KIRKLEES METROPOLITAN COUNCIL INVESTMENT & REGENERATION SERVICE

DELEGATED DECISION TO DETERMINE APPLICATIONS FOR CONSENT, AGREEMENT OR APPROVAL REQUIRED BY CONDITION

Reference No:	2022/44/91598/W
Site Address:	former, Stile Common Infant & Nursery School, Plane Street, Newsome, Huddersfield, HD4 6DF
Description:	Discharge of conditions 3 (Construction Management Plan), 4 (Construction Environmental Management Plan), 5 (road condition survey), 6 (Remediation Strategy), 9 (coal legacy) , 11 (estate roads), 12 (drainage under highway), 13 (highway retention), 14 (arboricultural method statement), 15 (Ecological Design Strategy), 16 (drainage scheme) and 17 (temporary drainage) of previous permission 2020/92067 for erection of 30 dwellings
Recommending Officer:	Nick Hirst

DECISION - Discharge of Conditions – Split Decision

TITLE				
TYPICAL DRAINAGE DETAILS SHEET 1 OF 3				
PROJECT				
PLANE STREET, HUDDERSFIELD				
CLIENT				
UNITY HOUSING ASSOCIATION				
DRAWING STATUS				
APPROVAL				
Scale	Date		Drawn	BHB
AS SHOWN © A1	APR 21		Chk.	RJ
Drg. No.				Rev
257/05/07.01				A

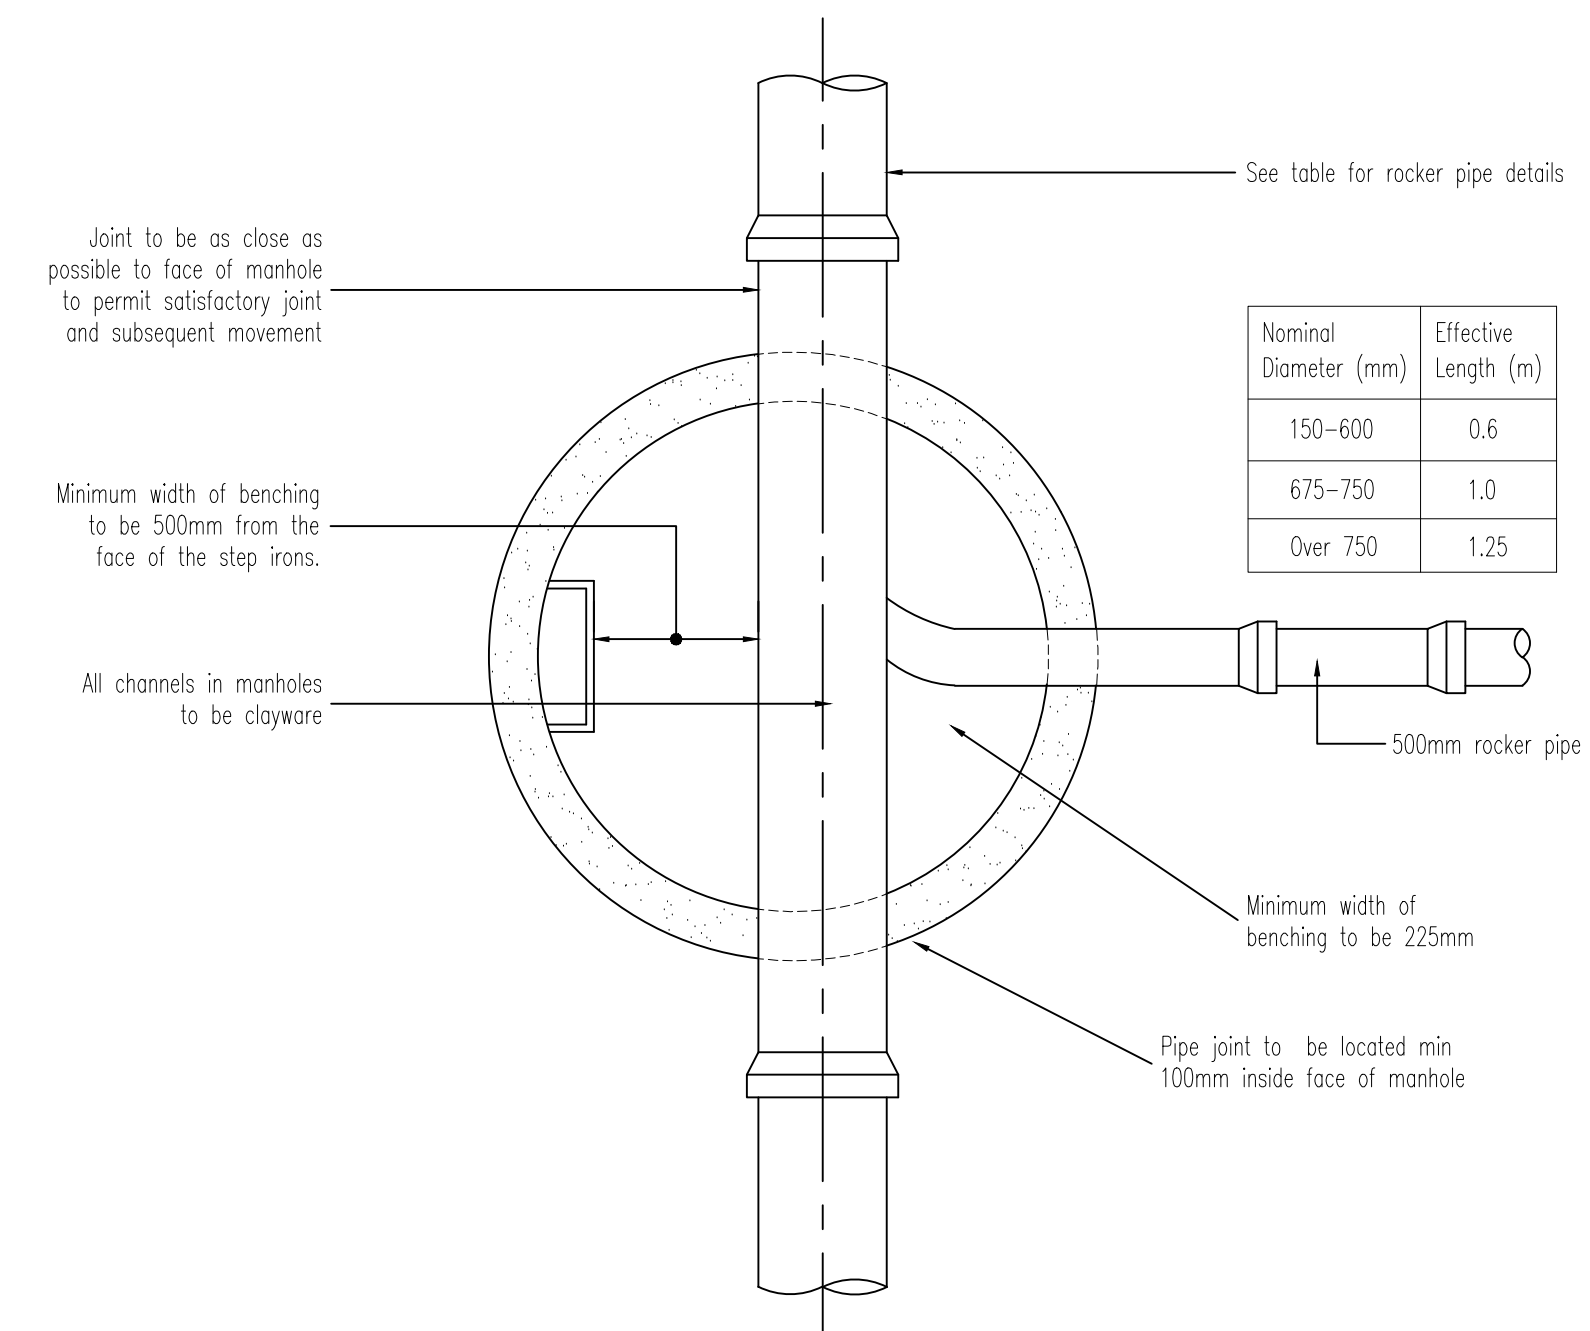
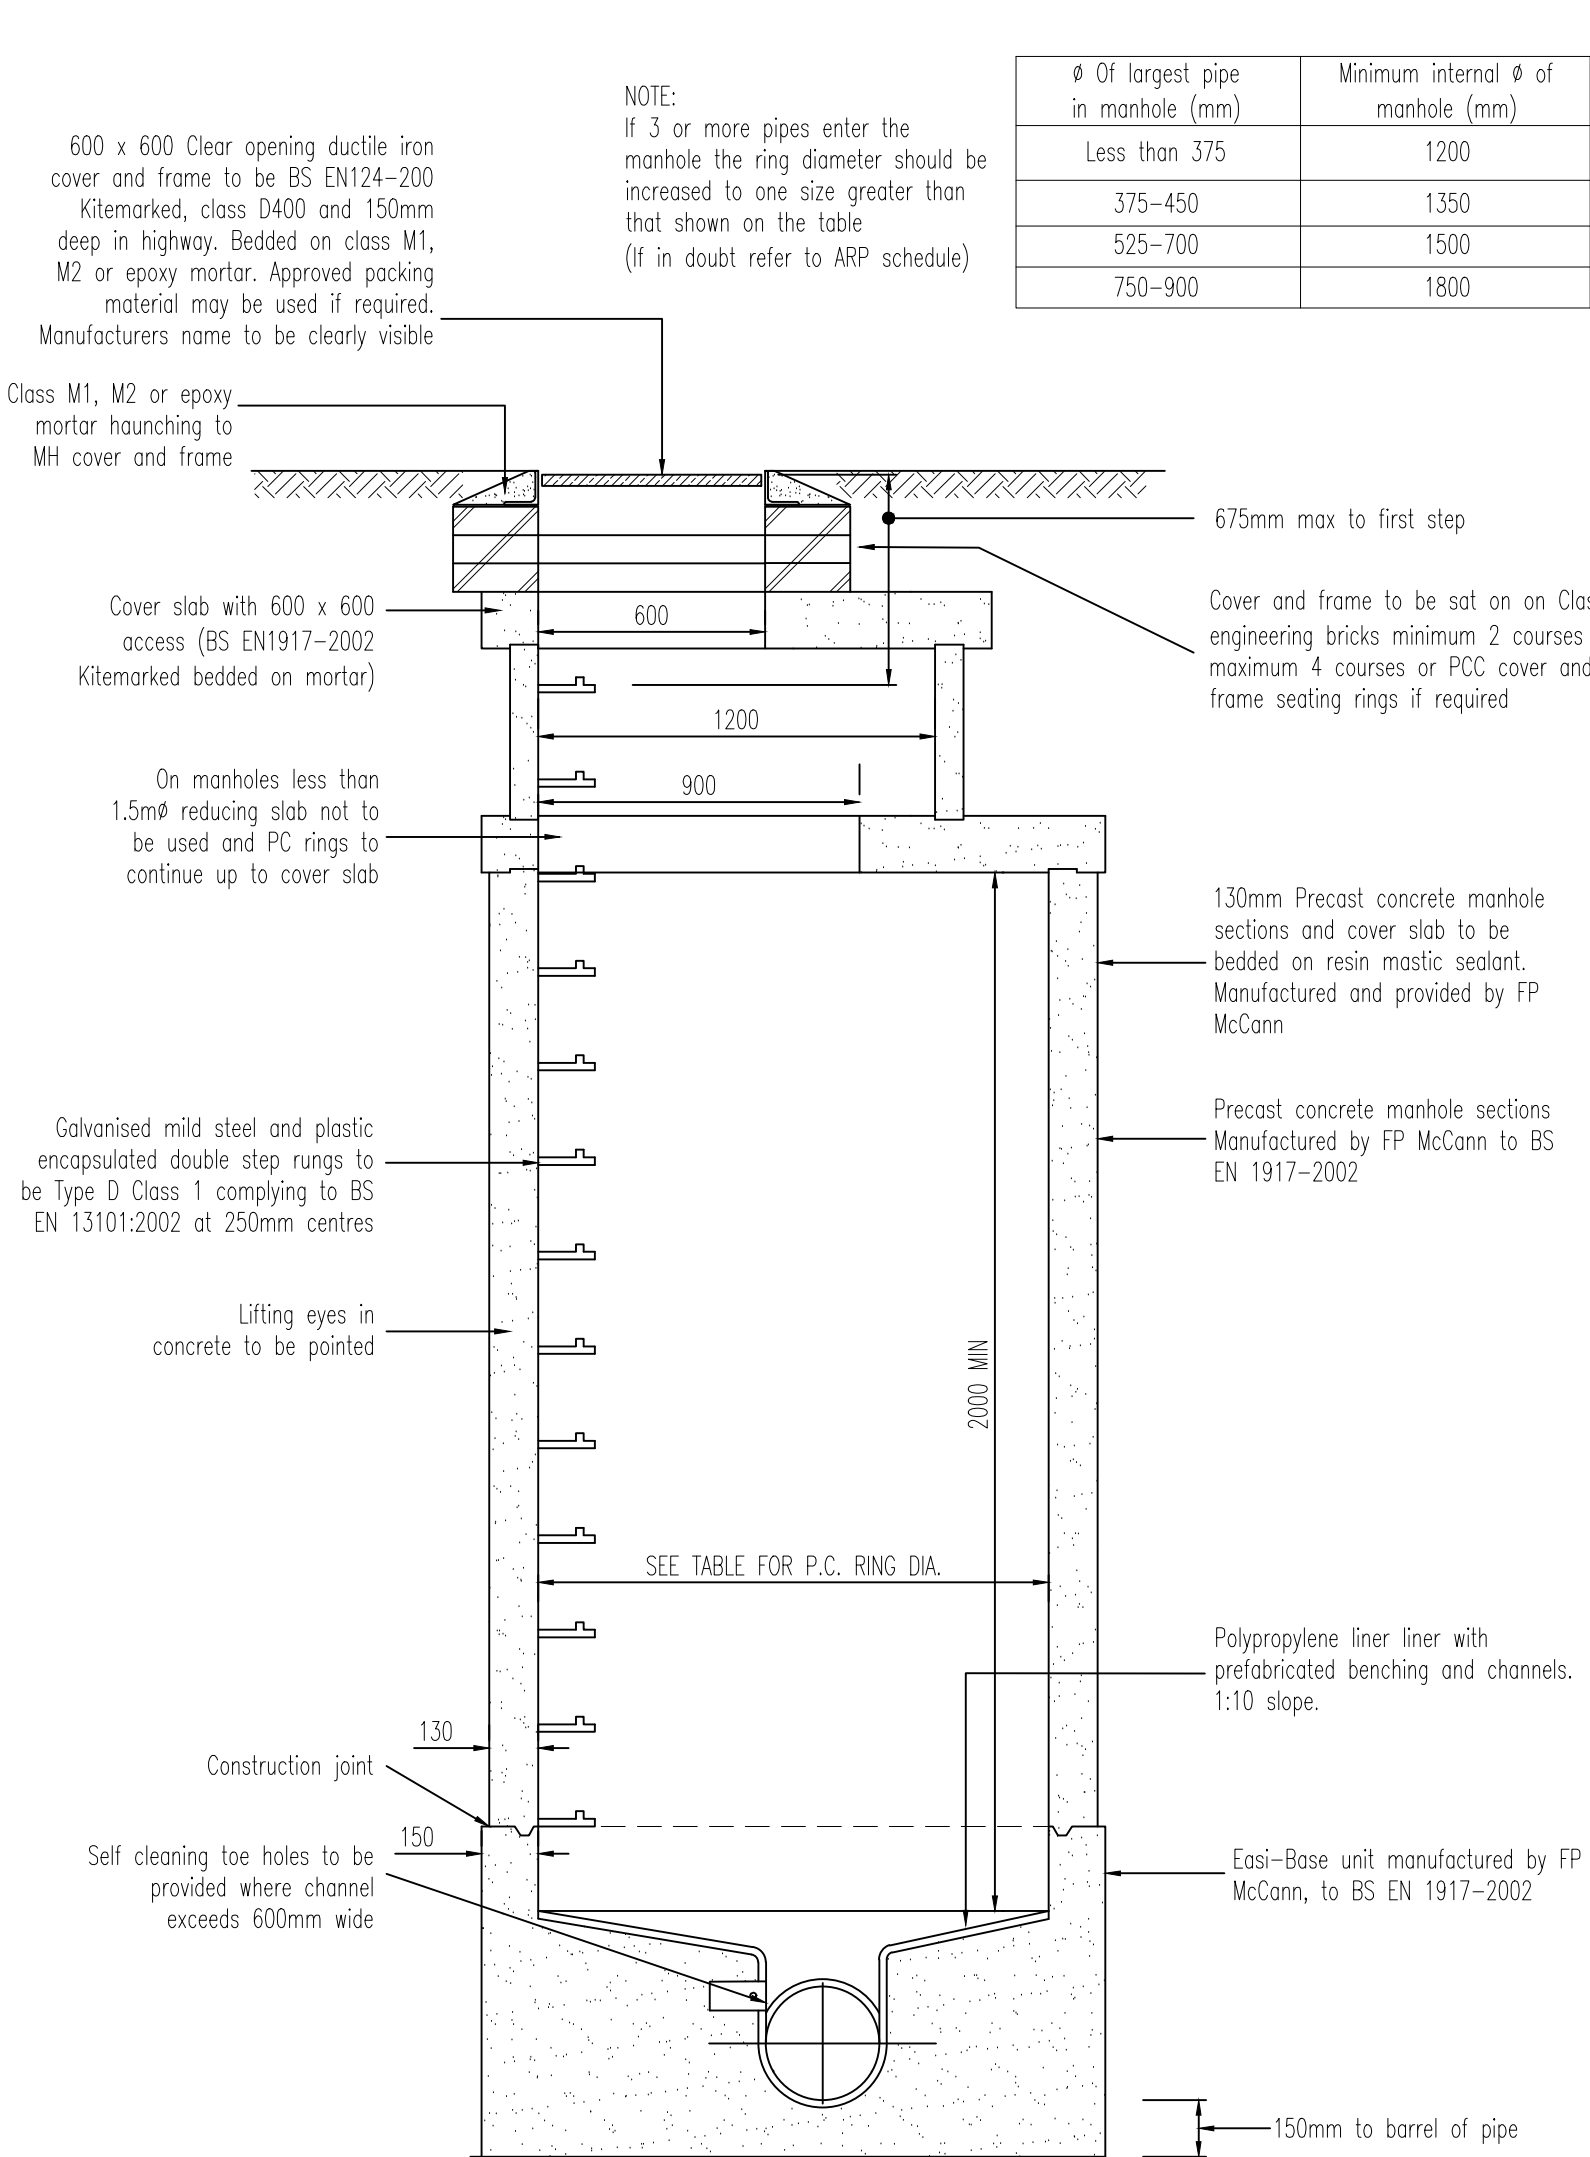
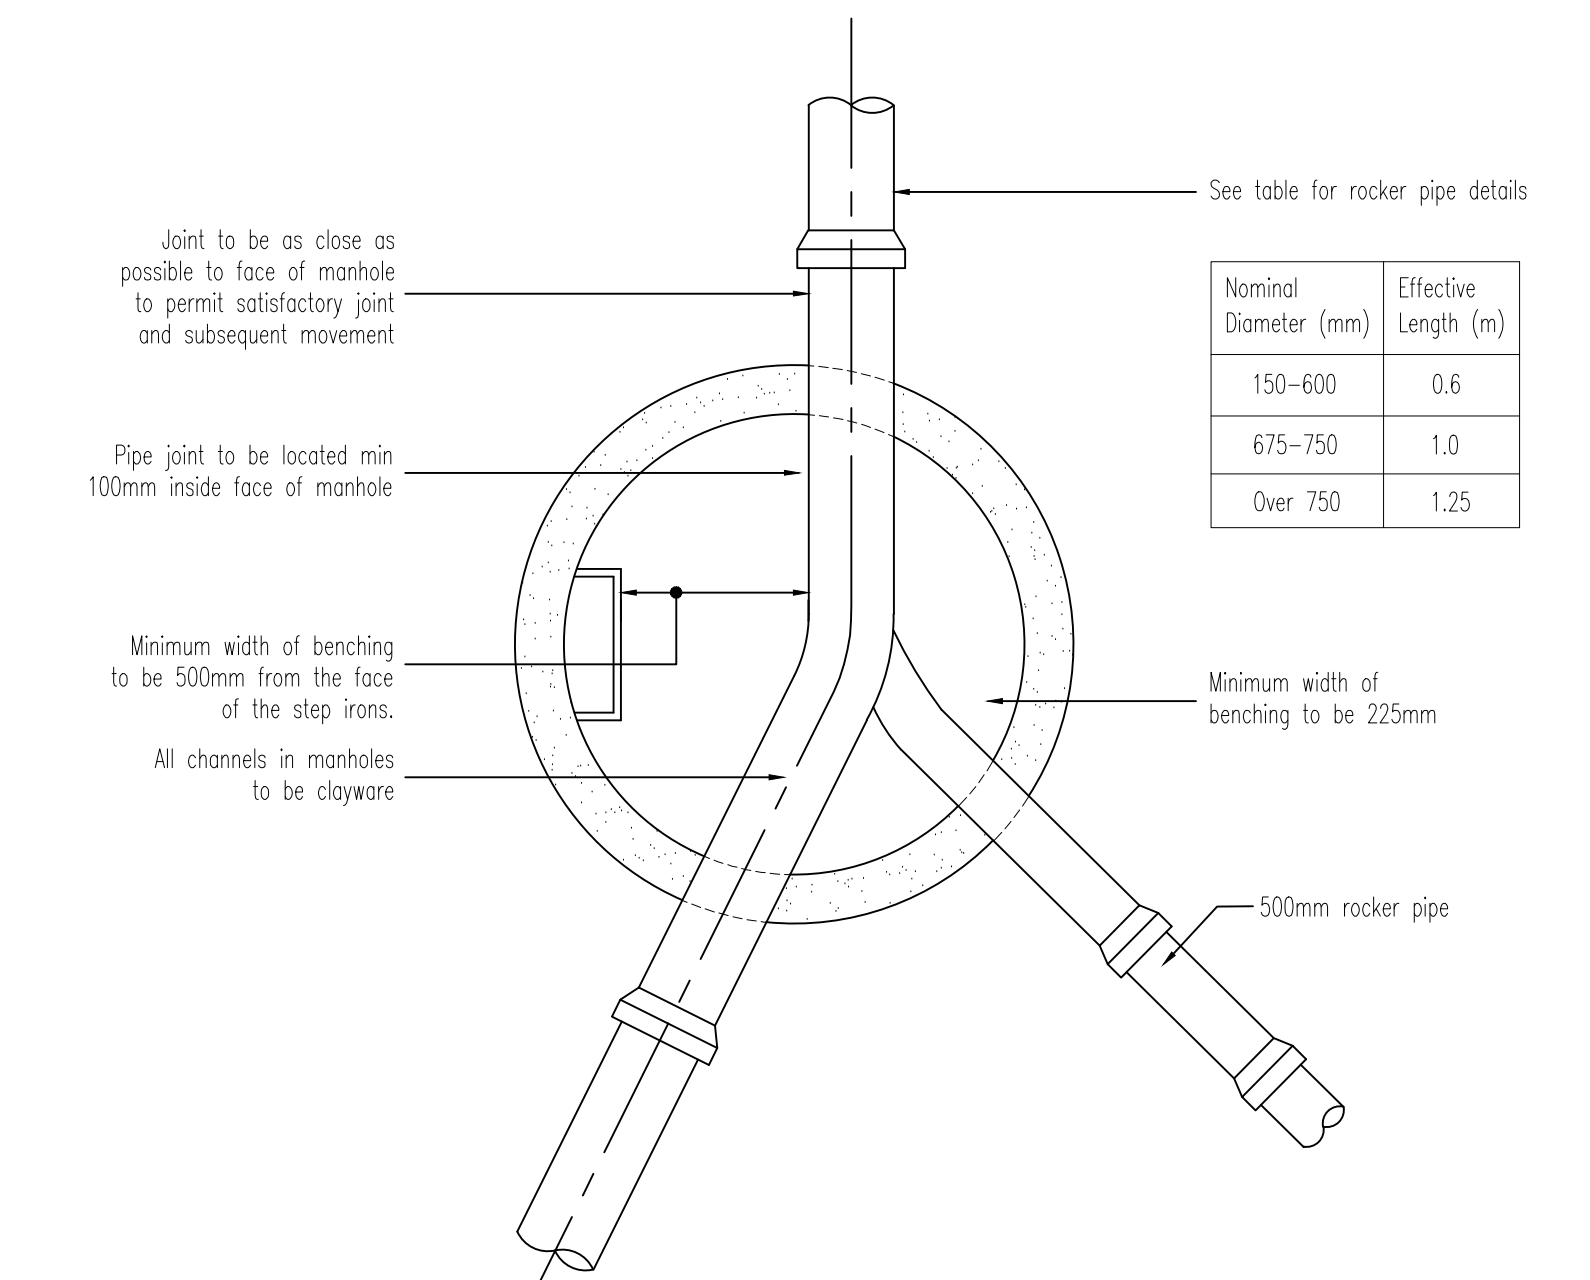
The submitted information is considered insufficient to discharge condition 16. Further information regarding the proposed surface water drainage scheme, including a condition survey of the surface water drain in Plane Street (via MH C1 on drawing 0257/05/03), is required, to demonstrate it is a suitable connection point. A CCTV survey of the existing drain should be supplied to indicate the condition of the pipework.
